CITY OF ALBUQUERQUE

April 16, 2012

**Re: BJ Restaurant- Winrock Mall, Conceptual Grading and Drainage Plan
Engineer's Stamp Date-no stamp- (J19-D058A)**

**BJS BUILDING PERMIT DRAINAGE PLAN**

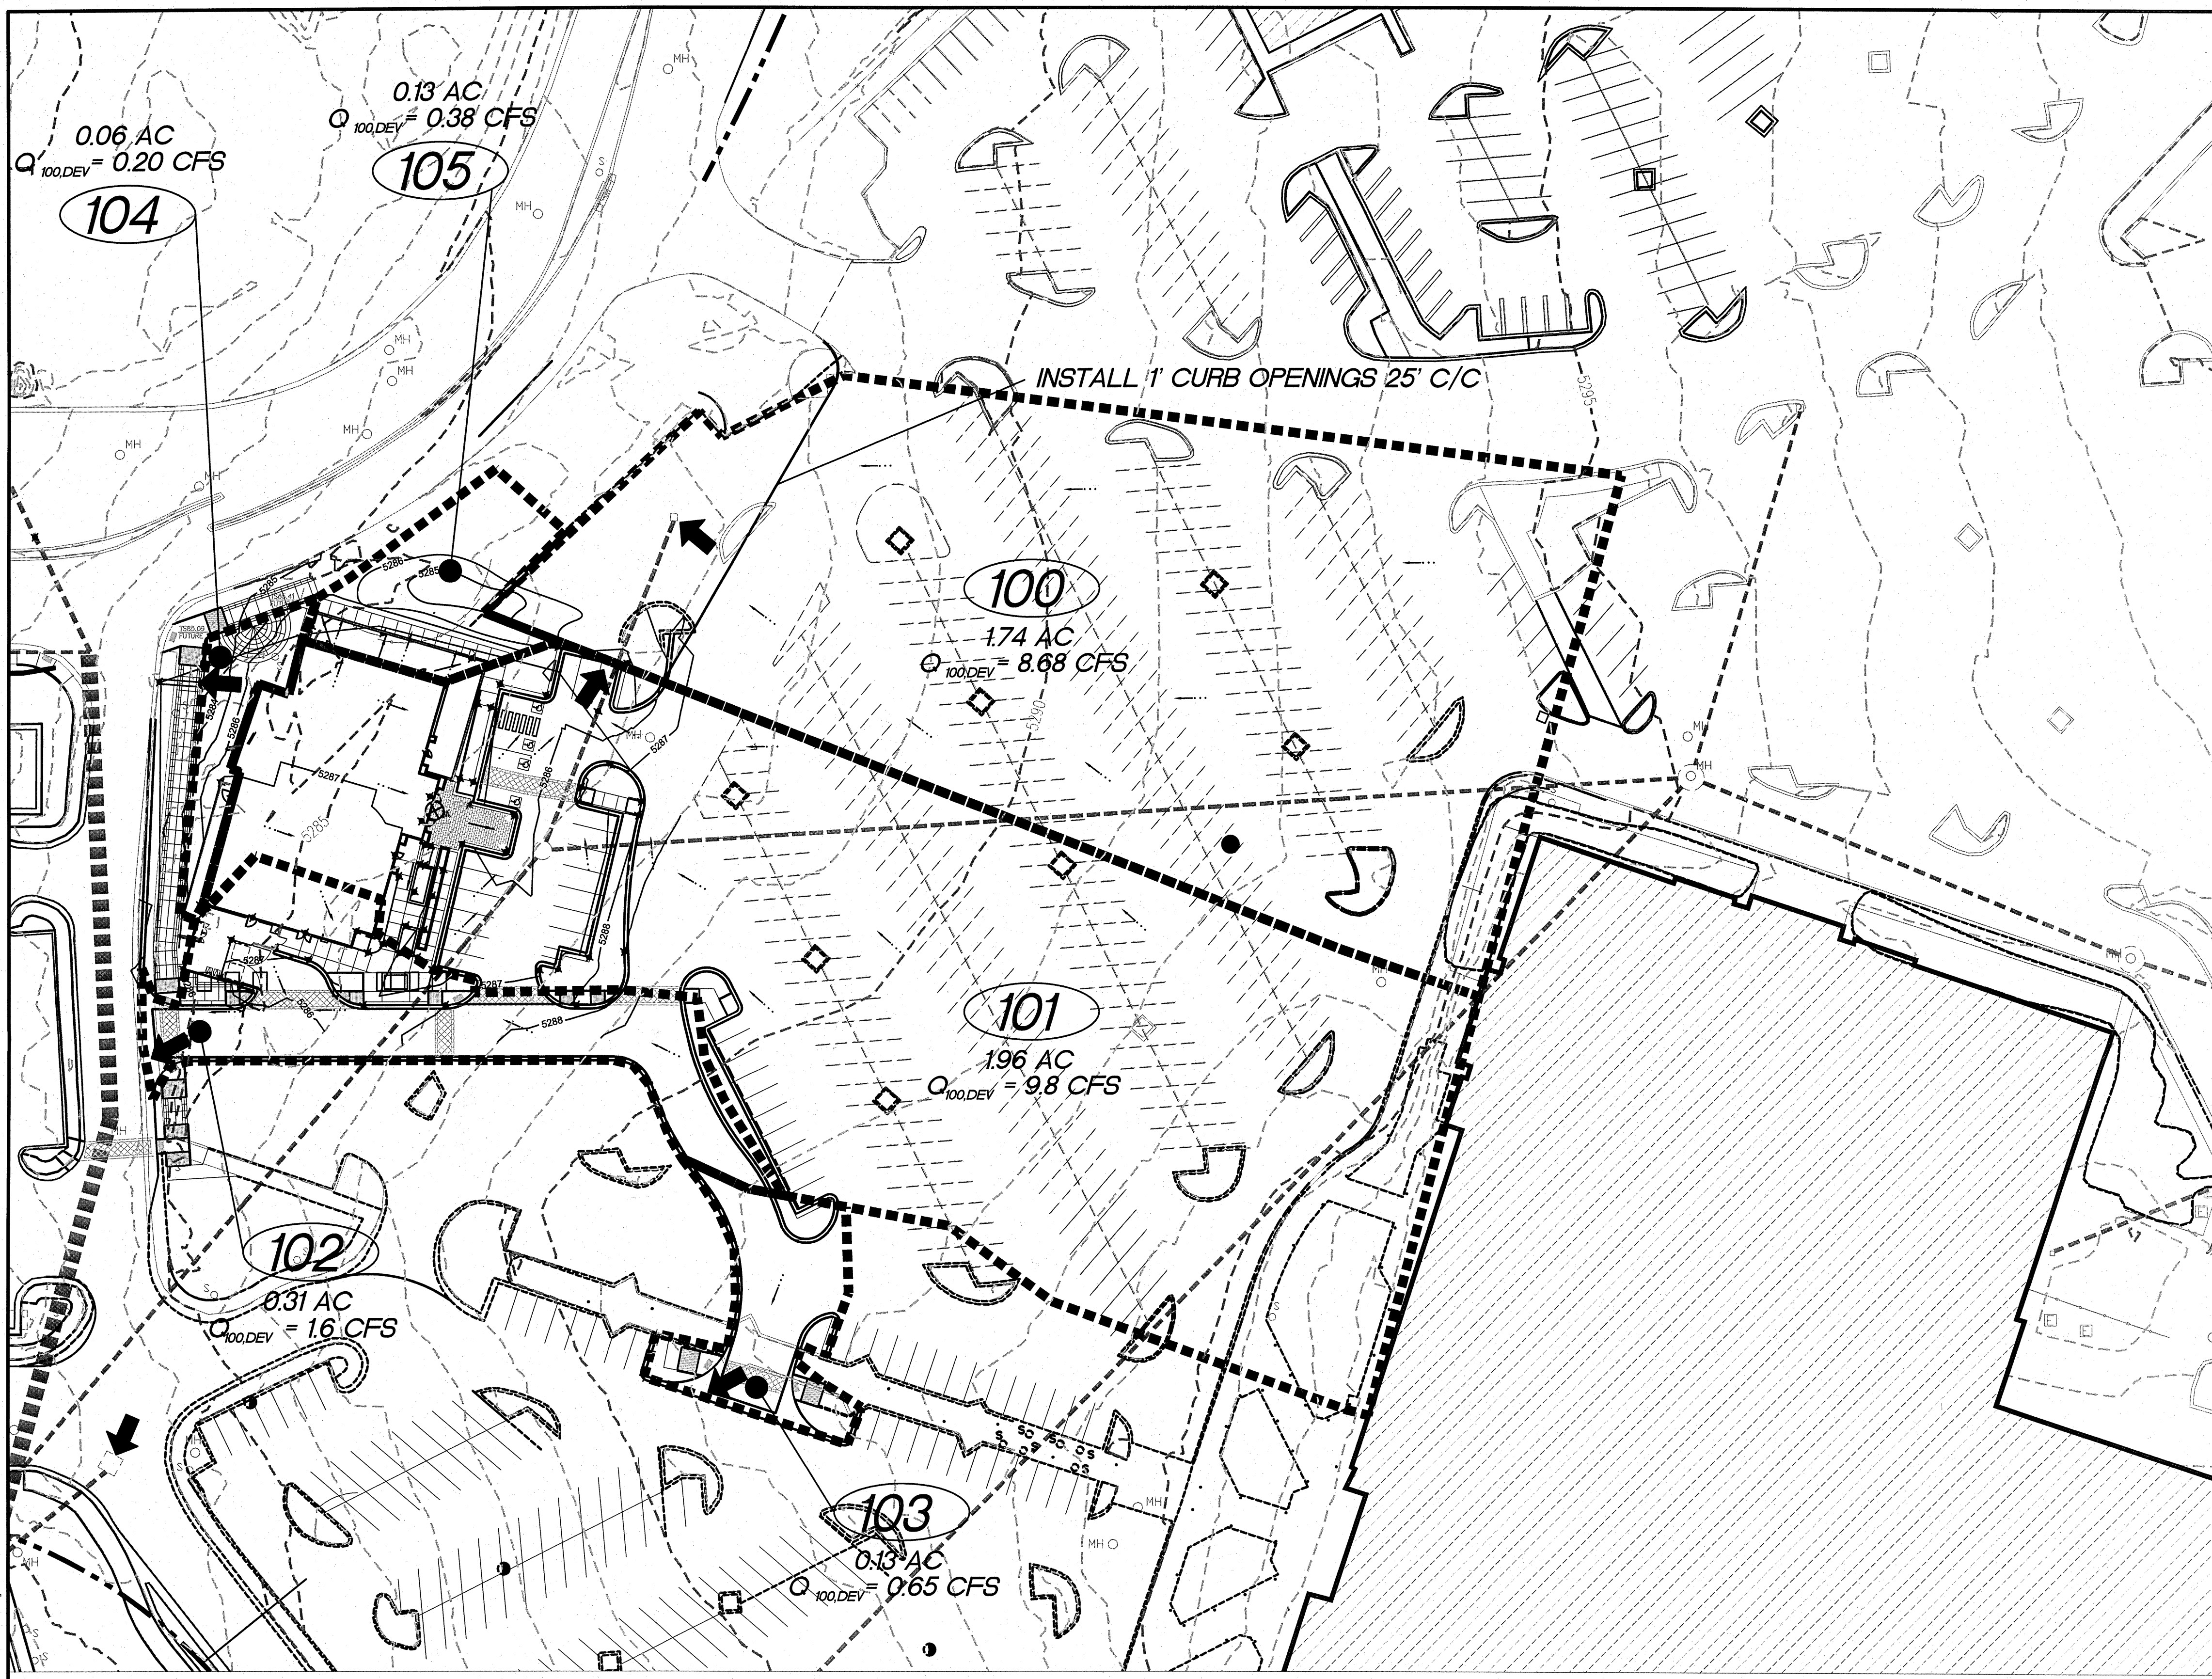
- A conceptual drainage plan should contain a narrative of how the site drains in the existing and proposed condition. The plan should also show all applicable existing and proposed storm drains.
